**Consultation Response from KC,
Highways Development Management**

2025/92961 Crown House, 12, Southgate, Huddersfield, HD1 1DE

Date Responded: 31/12/2025

### **GENERAL ACCESS ARRANGEMENT AND SWEEP PATH AUTOTRACK ANALYSIS**

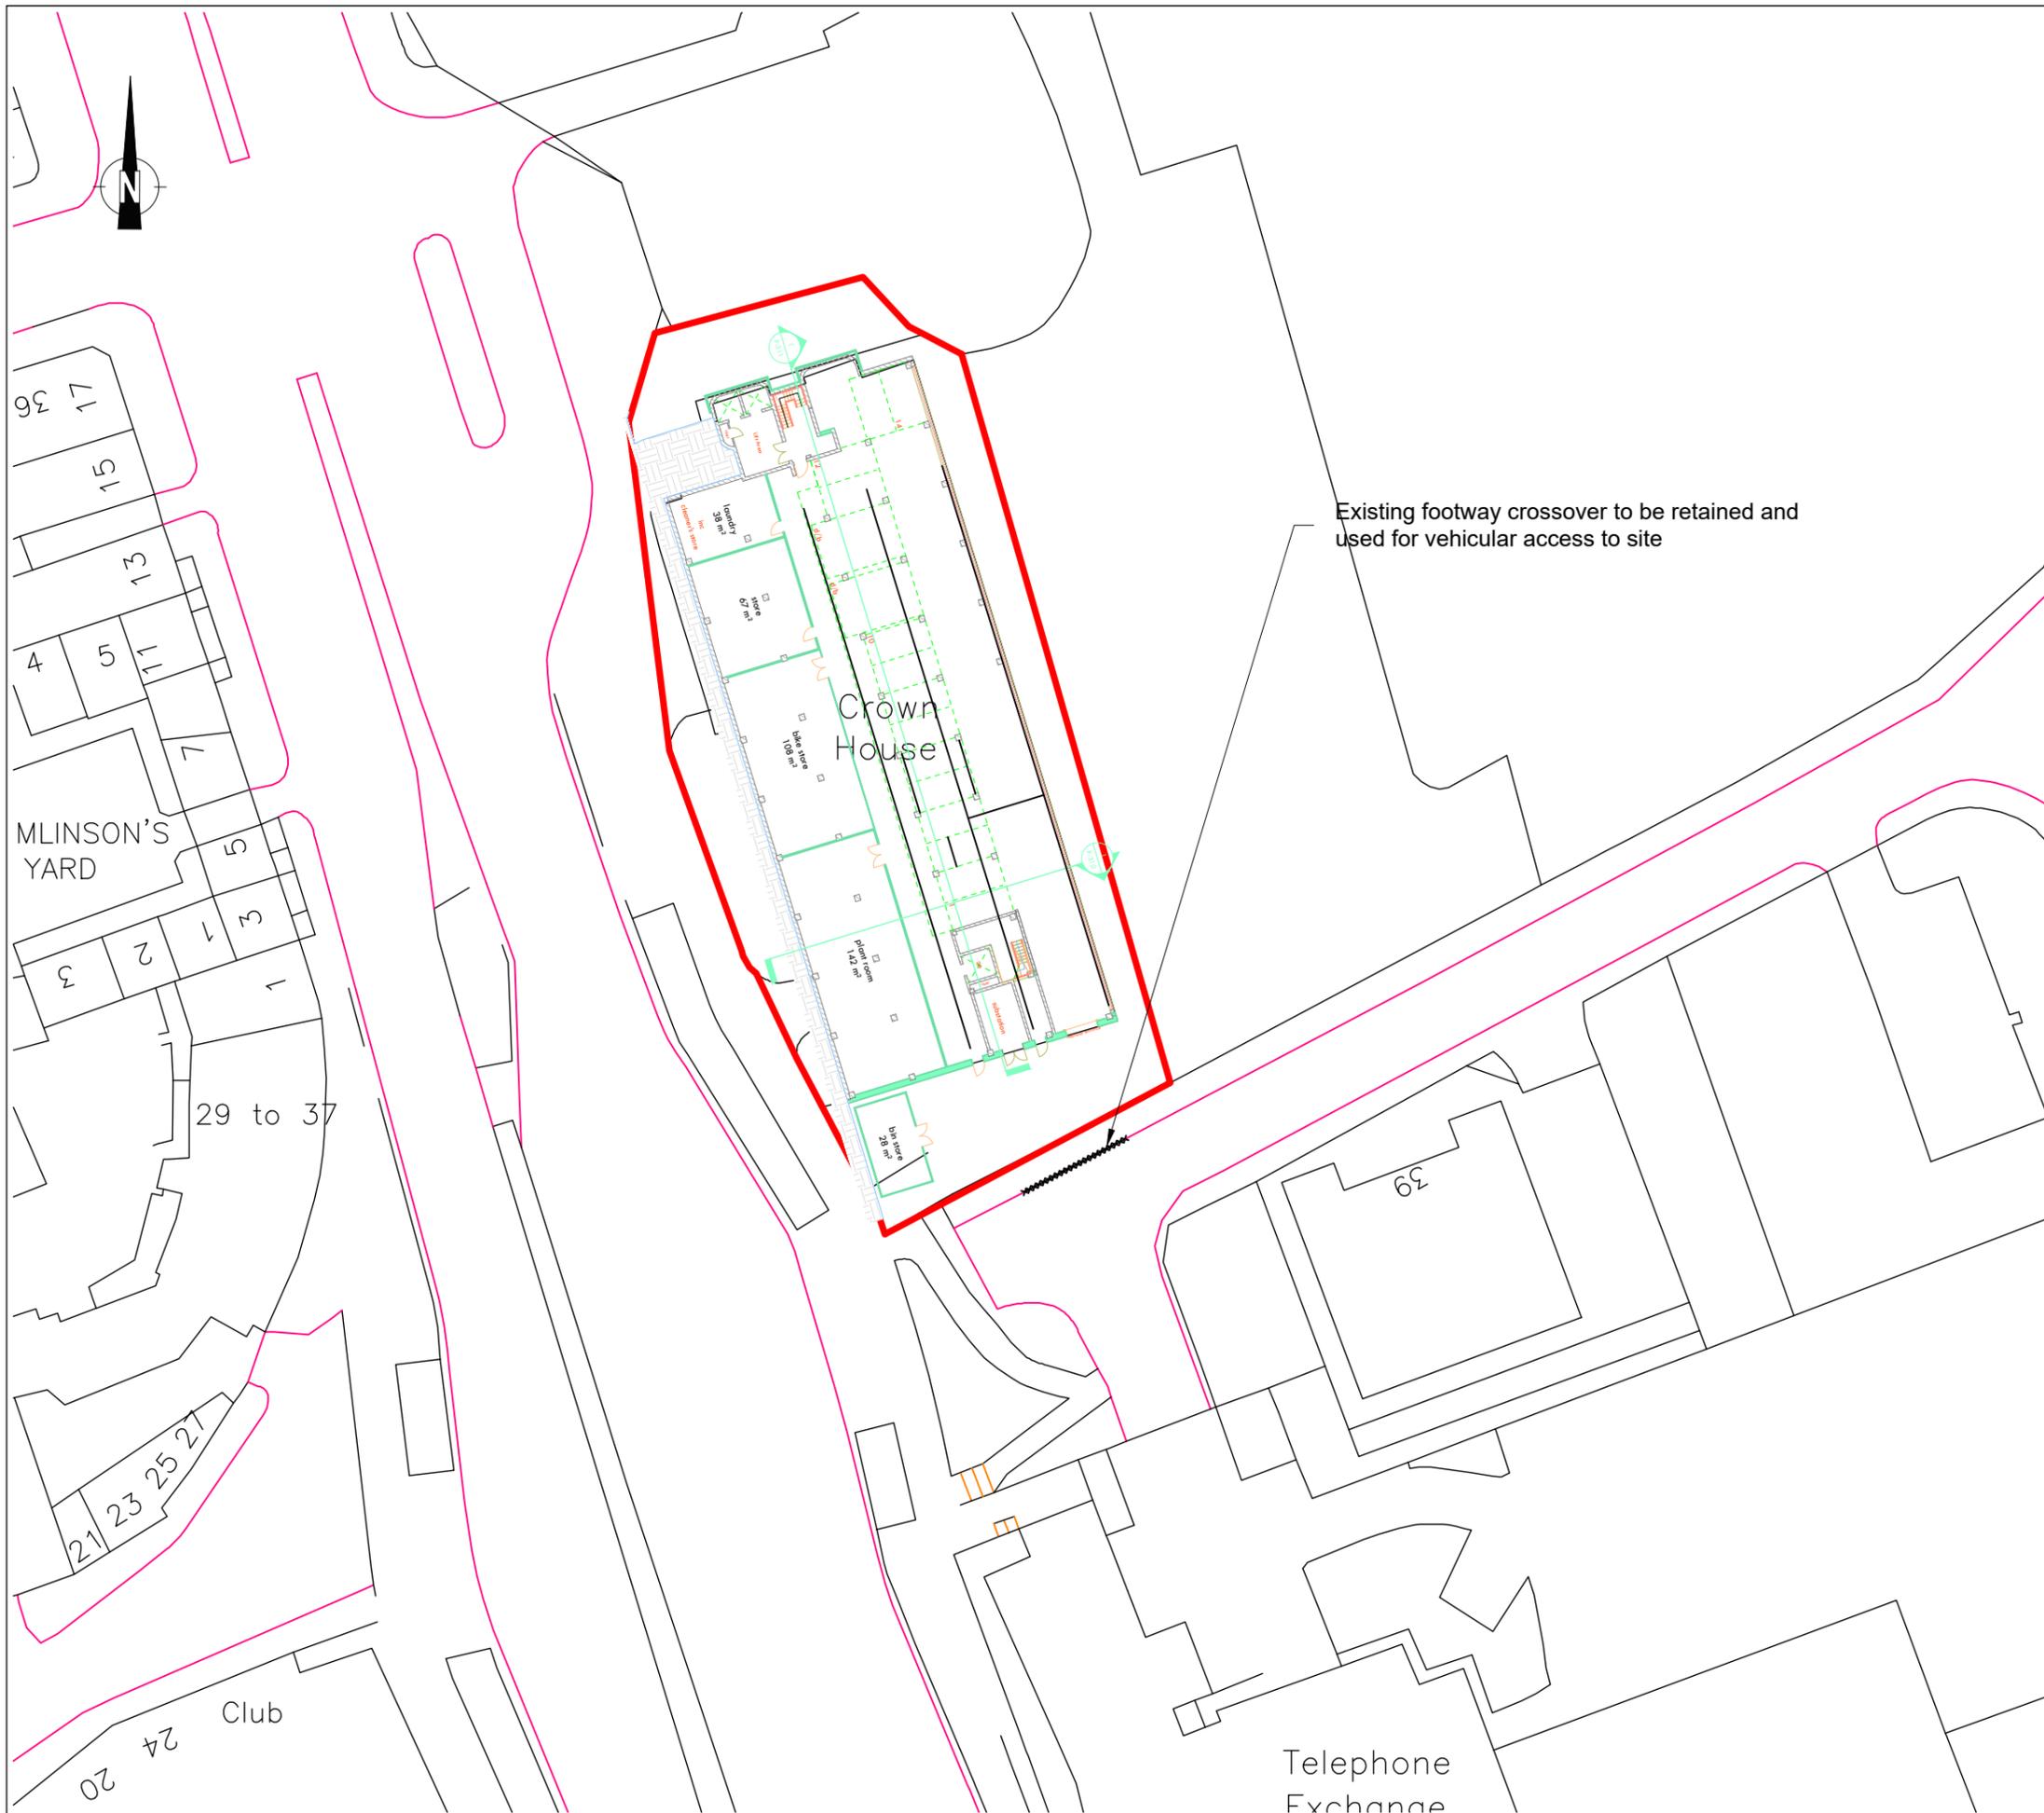
- Details of construction access arrangements; - **These are indicated on the drawing included in Annexe A of the CEMP via Leeds Old Road, and this is acceptable.**

- Loading and unloading of plant and materials; - **These are indicated within Section 4.6 and are on the drawing included in Annexe A of the CEMP via Leeds Old Road, and this is acceptable.**

- Storage of plant and materials; - **These are indicated on the drawing included in Annexe A of the CEMP via Leeds Old Road, and this is acceptable.**
